Our ref: KT/2022/129574/01-L01
Your ref: EN010135-000006

Planning Act 2008 (as amended) and the Infrastructure Planning (Environmental Impact Assessment) Regulations 2017 (The EIA Regulations)– Regulations 10 and 11 application by Evolution Power Limited (The Applicant) for an order granting development consent for the Stonestreet Green Solar (The Proposed Development).

Scoping consultation and notification of the applicant's contact details and duty to make available information to the applicant if requested.

Land at Aldington, southeast of Ashford in Kent (Stonestreet Green Solar)

Figure 10.7

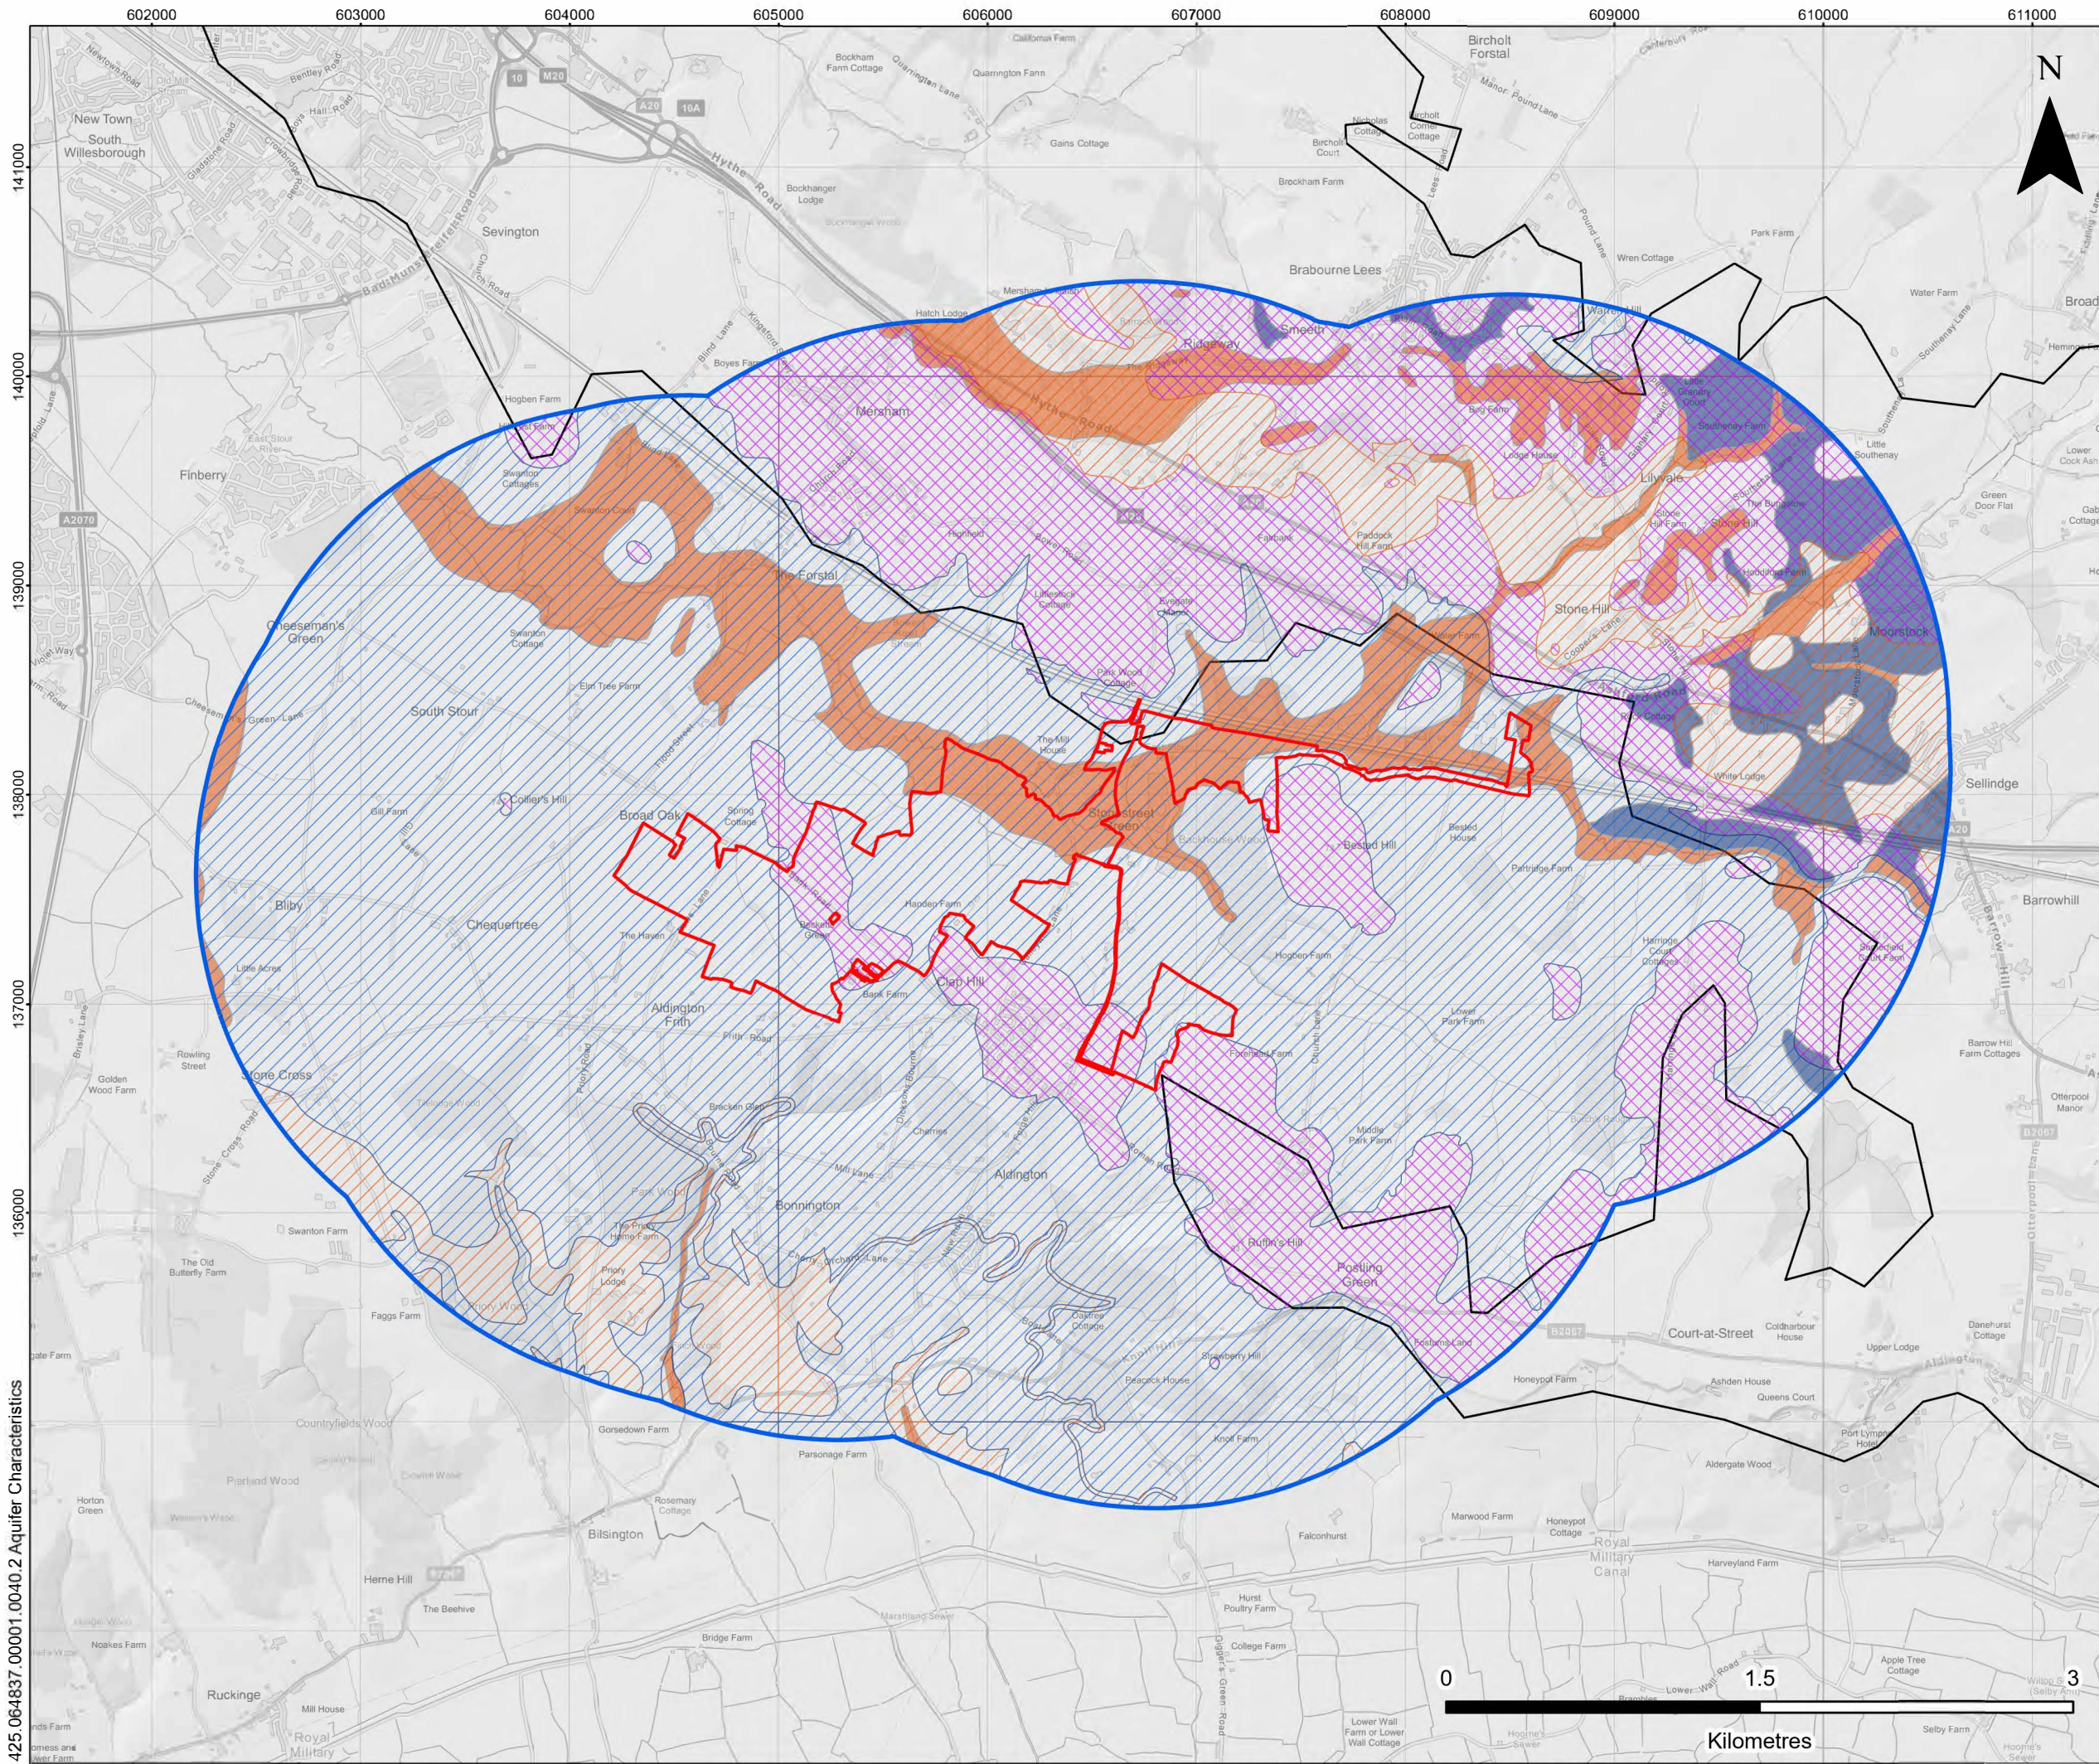
This site partly overlies a chalk aquifer and Secondary A aquifer. Any pathways for contamination must be strictly controlled to avoid pollution of the principal and secondary aquifers from any historic contamination identified on the site from any previous uses, including historic landfilling.

**Appendix 10-4: Aldington Flood Storage Area Risk  
Assessment**

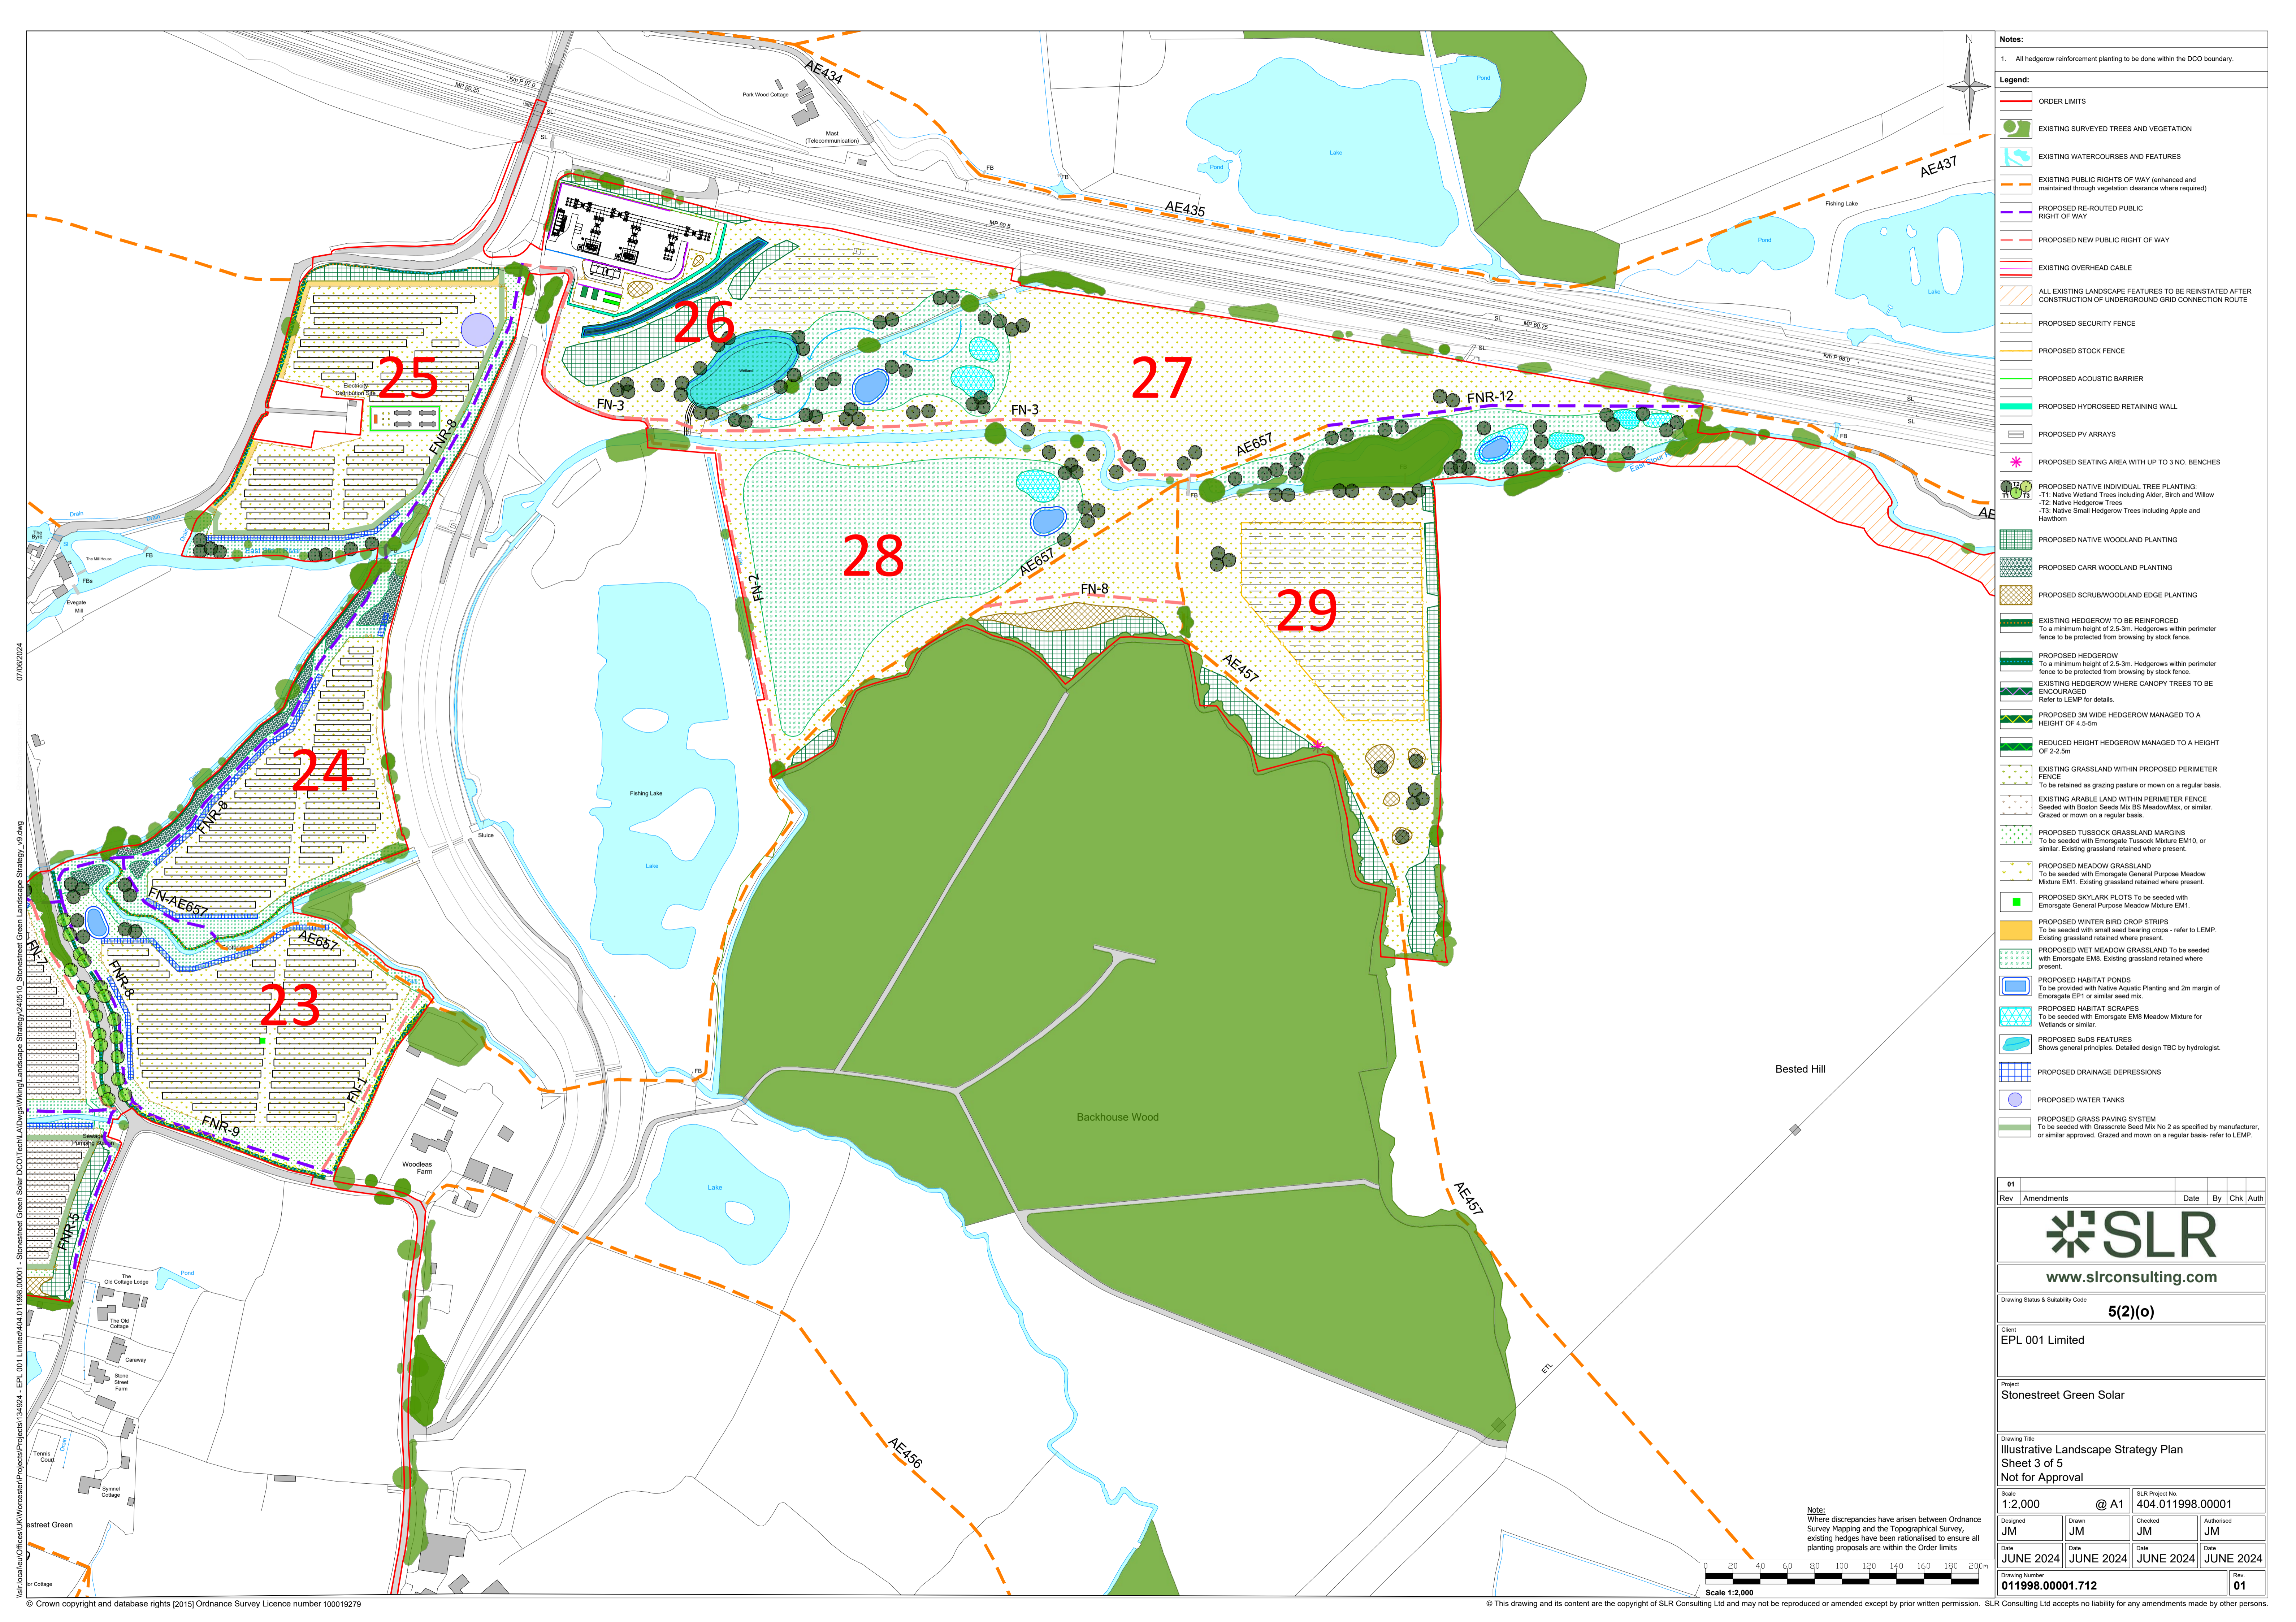
This section should include an assessment of the proposal's impact on the Aldington Flood Storage Area. It is important that the development does not in any way compromise the function or efficacy of the FSA.
